Application no: H14/0707/03
Original Applicant: P & L P C Kalmar
Kalyn Haza
Small Drove Lane
West Pinchbeck
Spalding, Lincs. PE11 3NL

Description: Extension to form granny annex

Location: Kalyn Haza
Small Drove Lane
West Pinchbeck

Amendment: Amend exterior finish from render to brickwork on south/
west elevation, west elevation of garage & porch to north

REVISION REQUEST
SEPT 2003

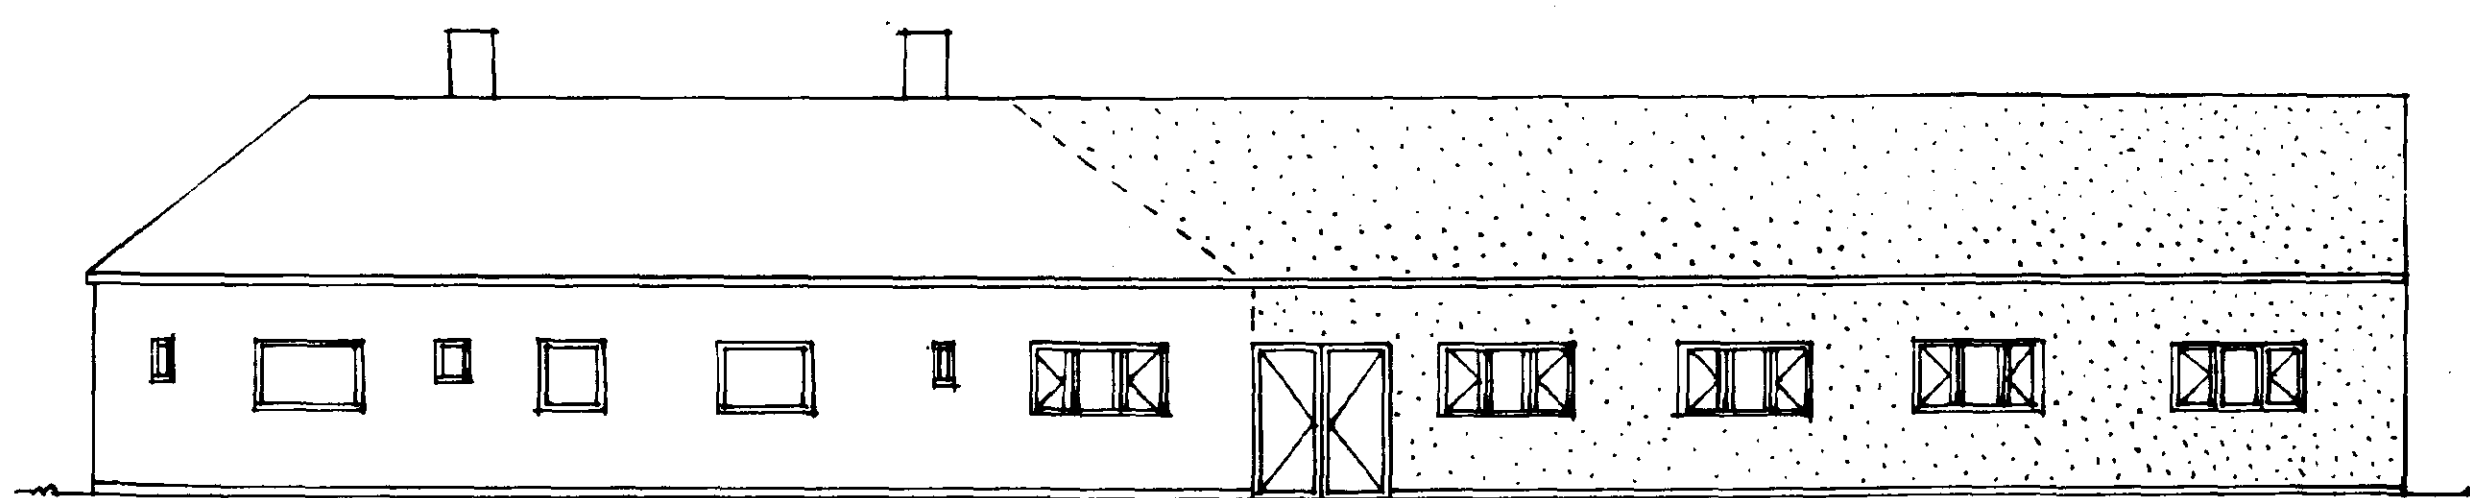
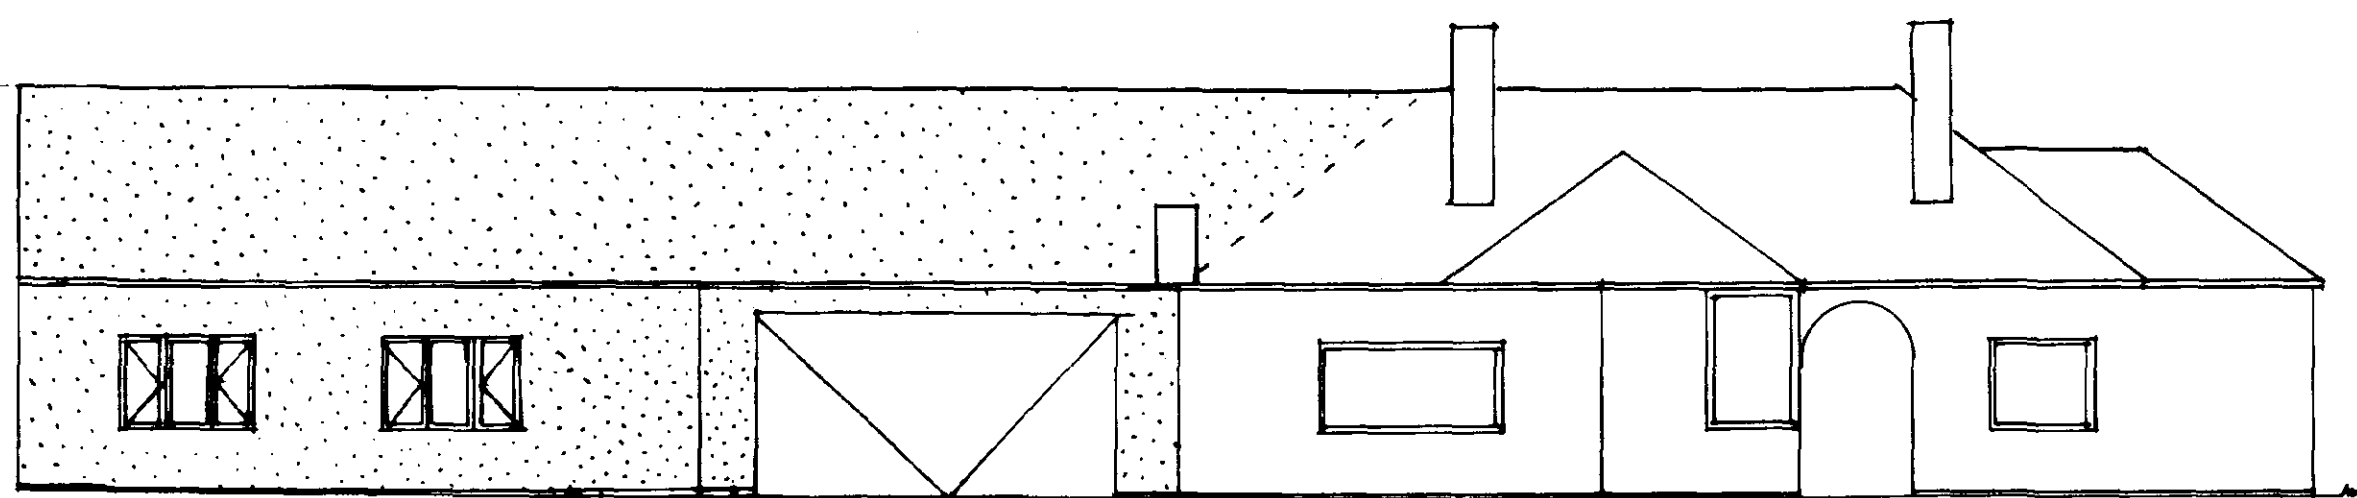
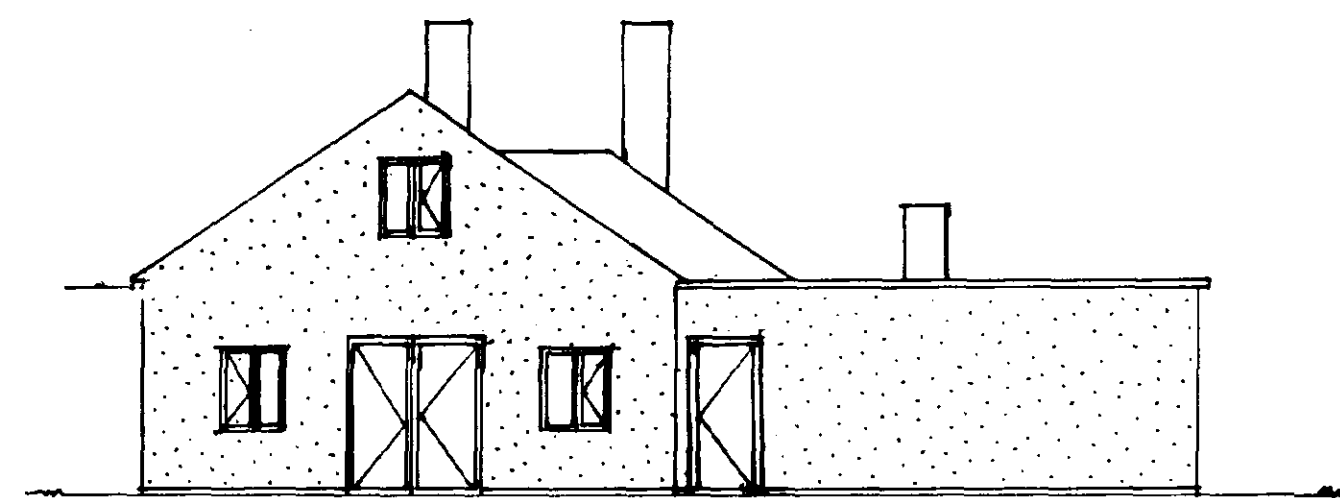
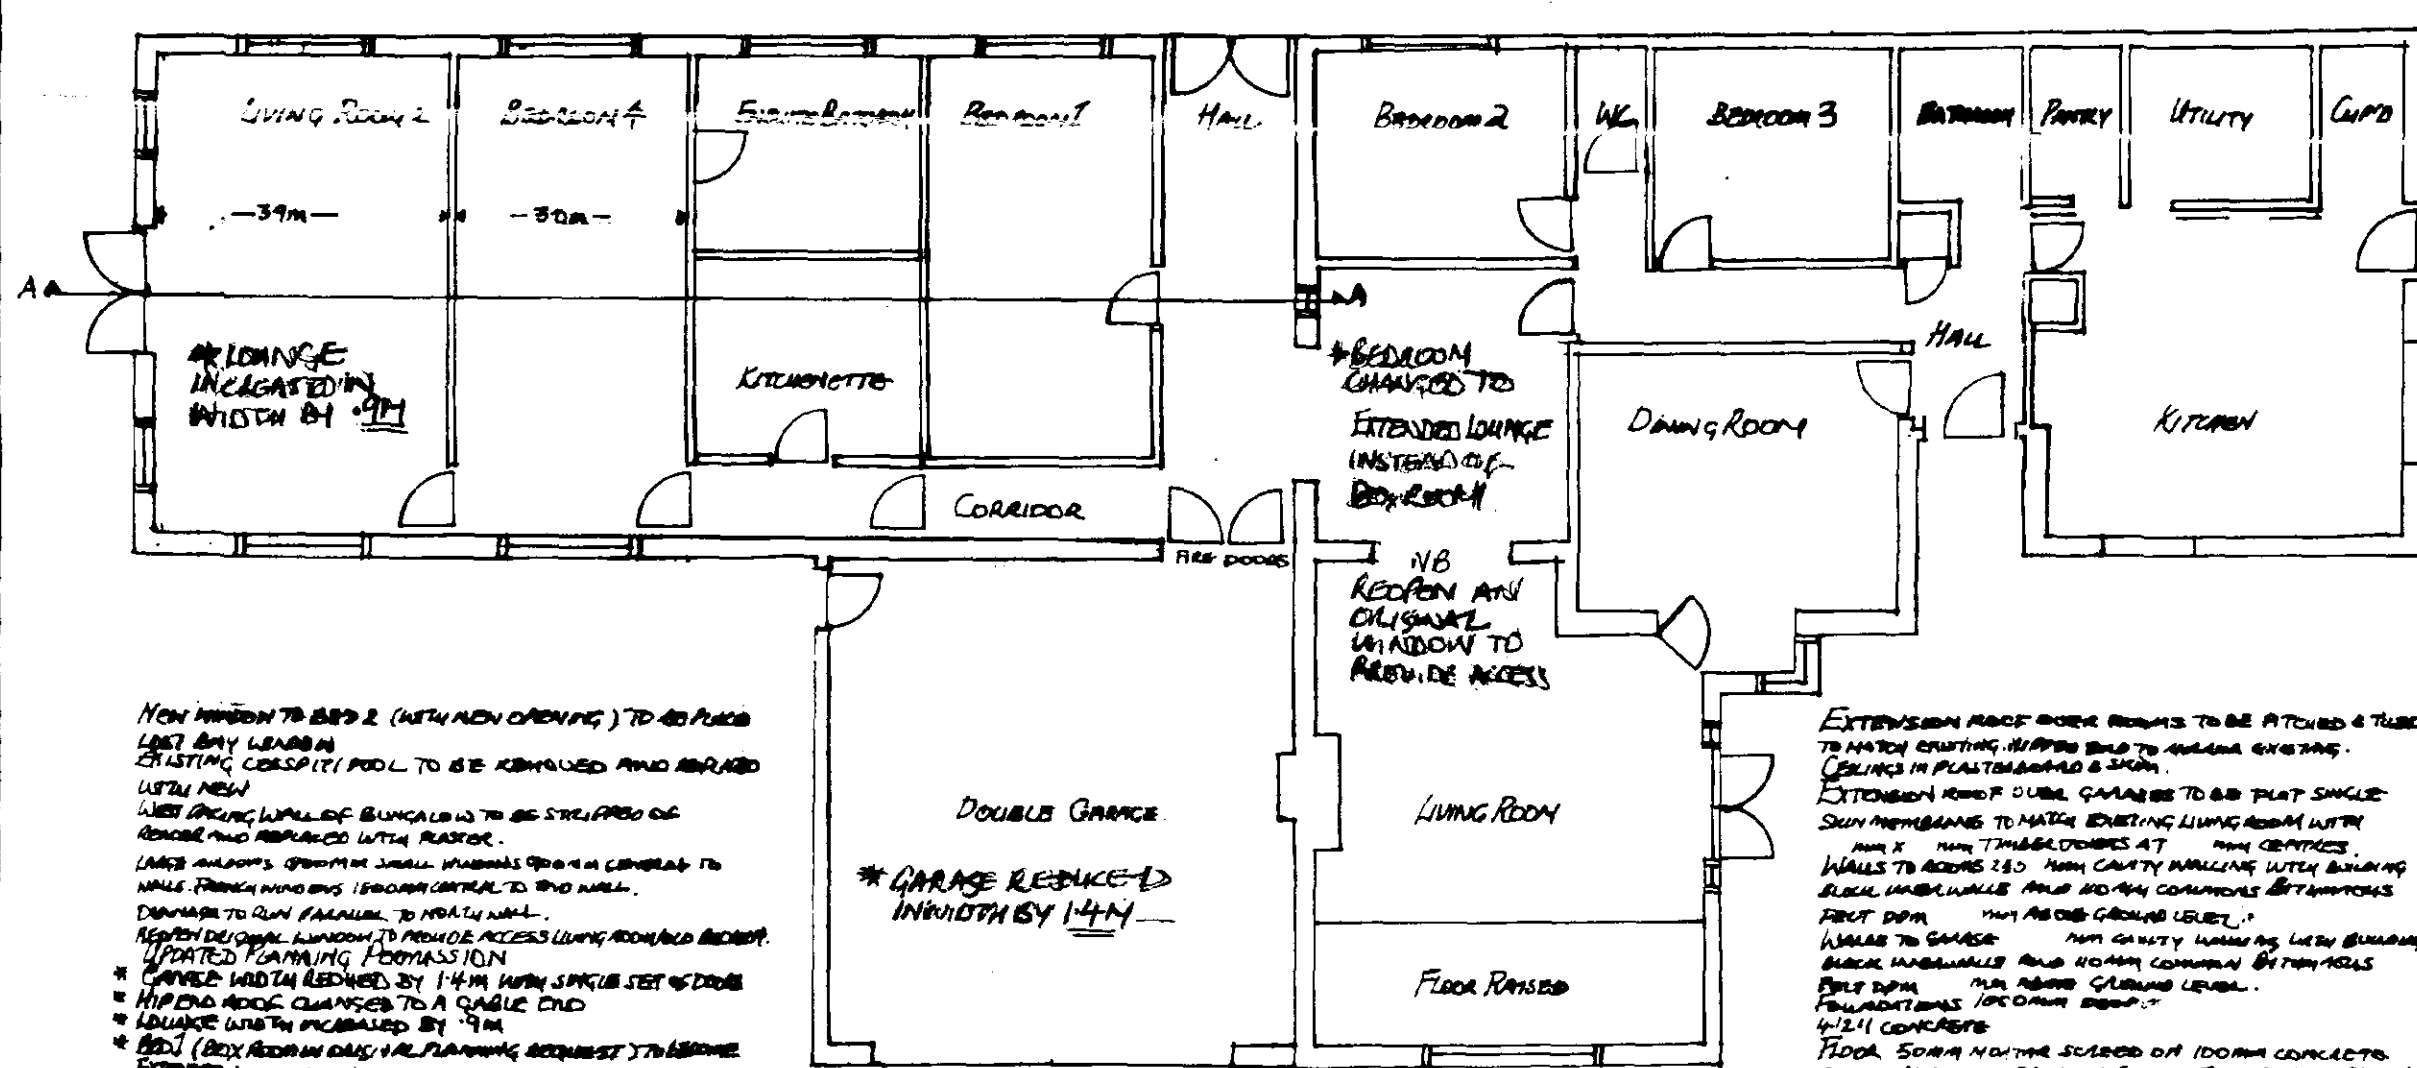
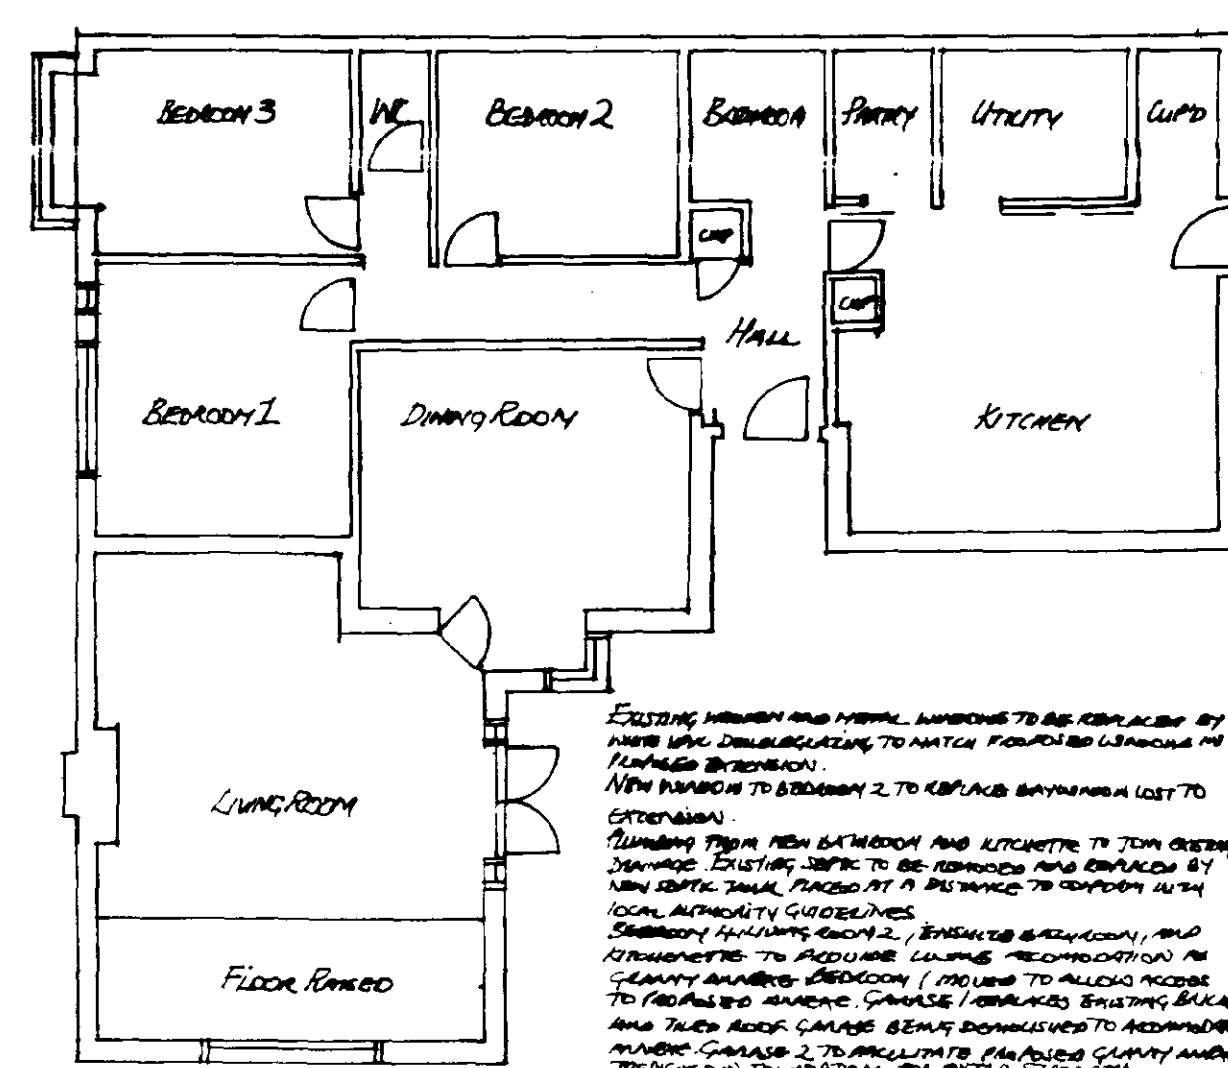
Amendment: Reduced garage width, increased lounge width and
roof changed to gable end.

Further to receiving planning permission we would like to submit a revision. We enclose a revised drawing of the original planning permission for comparison. The effected areas have been highlighted in colour. Listed below are the specific changes we would like to make:

- The **garage width** is to be *reduced* by 1.4m.
- Approximately $6.7\text{m} \times 1.4\text{m} = 9.38\text{msq}$
-
- The **lounge width** is to be *increased* by .9m
- Approximately $6.3\text{m} \times .9\text{m} = 5.67\text{msq}$
-
- N.B. This results in an *overall reduction* of approximately $9.38 - 5.67 = 3.71\text{msq}$
-
- The new hip end roof to be *changed* to a **gable end**.
